Application No: BR/233/21/HH
Site Address: 77 Hillsboro Road Bognor Regis PO21 2DY
Description of works: Hip to gable loft conversion with 2 x side dormers

Thank you for your internet representation made on 11th November 2021 which has been recorded as an objection with the comments as follows:

PROPOSED ELEVATIONS

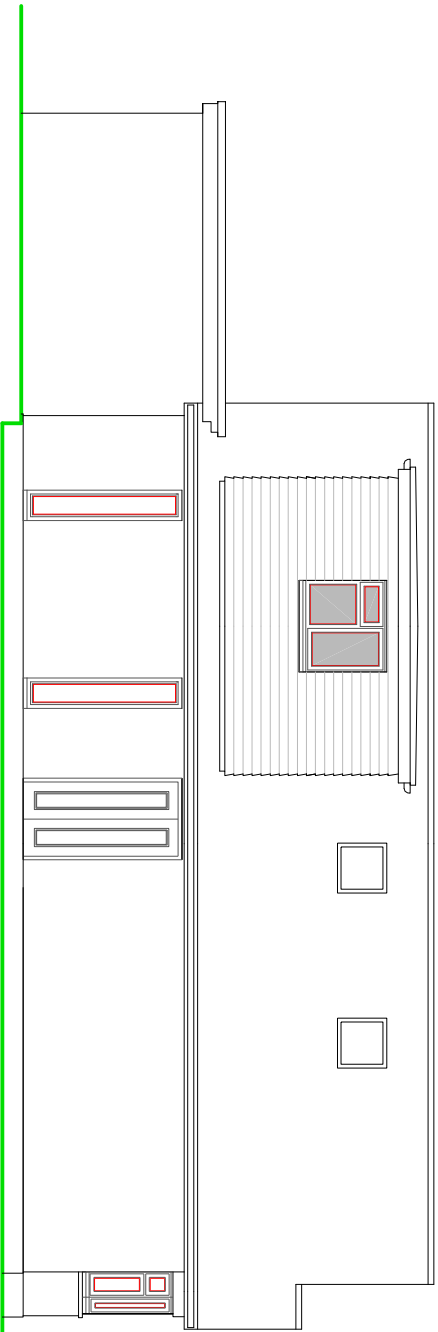
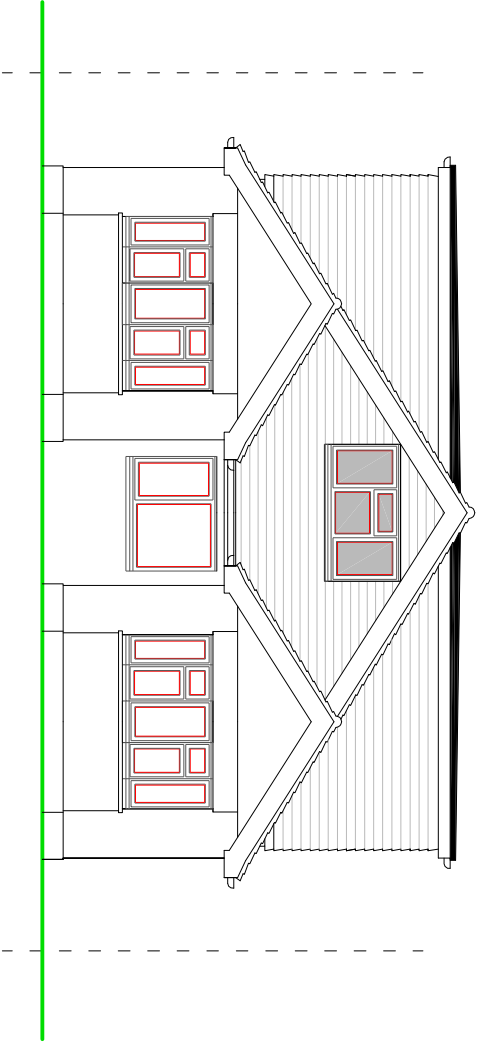
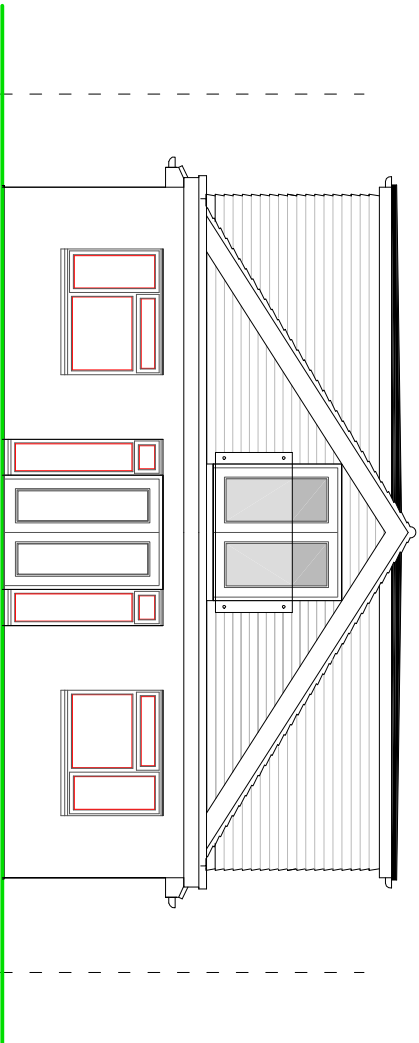
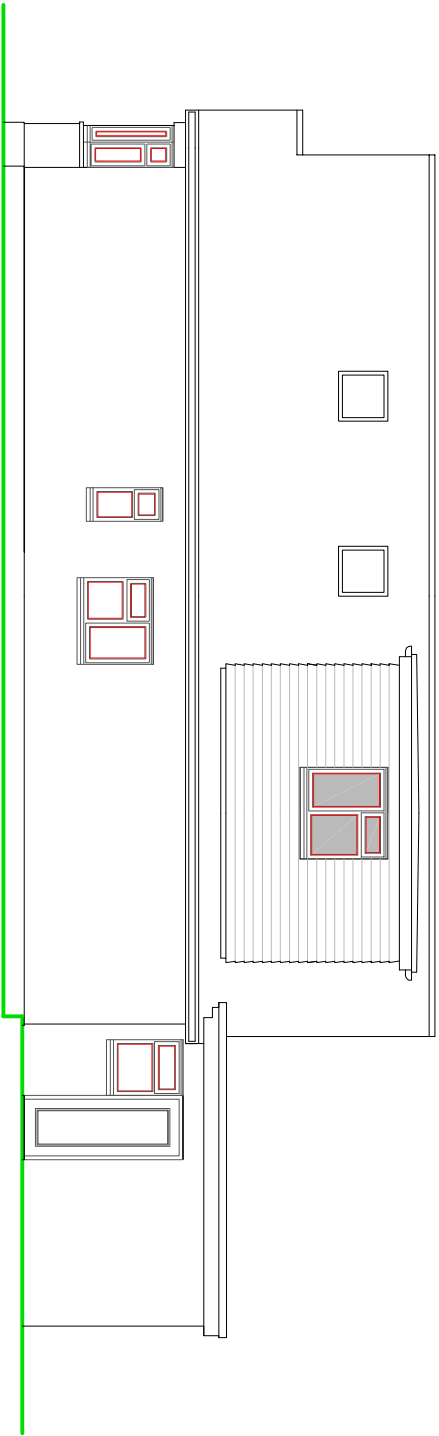
As you look at the property from the road, we are concerned about all the windows to the left of the property as we believe this will affect our privacy and light into our property. We don't want the hall and front bedroom window installed but we are happy with the dormer window as long as it does not open and has obscure glass so you can't see through it as per the plans.

If all these windows are to be fitted then they should not be able to open any of them and must have permanent screen covers on both windows so they are unable to see out of the them as they would look directly onto our young son's bedroom.

Ideally we would prefer that there are no windows for the hall or the front roof bedroom to the left of the property. We have one window in our roof room hall and this currently lets in enough light therefore we do not believe they would require 2 windows in the hall. Our property has been extended into the loft and we now have restrictions down the entire left side where the windows can't be opened and have screen covers on all of them to protect our neighbour's privacy. We now feel that we don't want to be restricted down the right side of our property in opening windows due to the privacy that will be lost if these windows are added. As these restrictions have been actioned with our property we do not believe this is an unreasonable request.
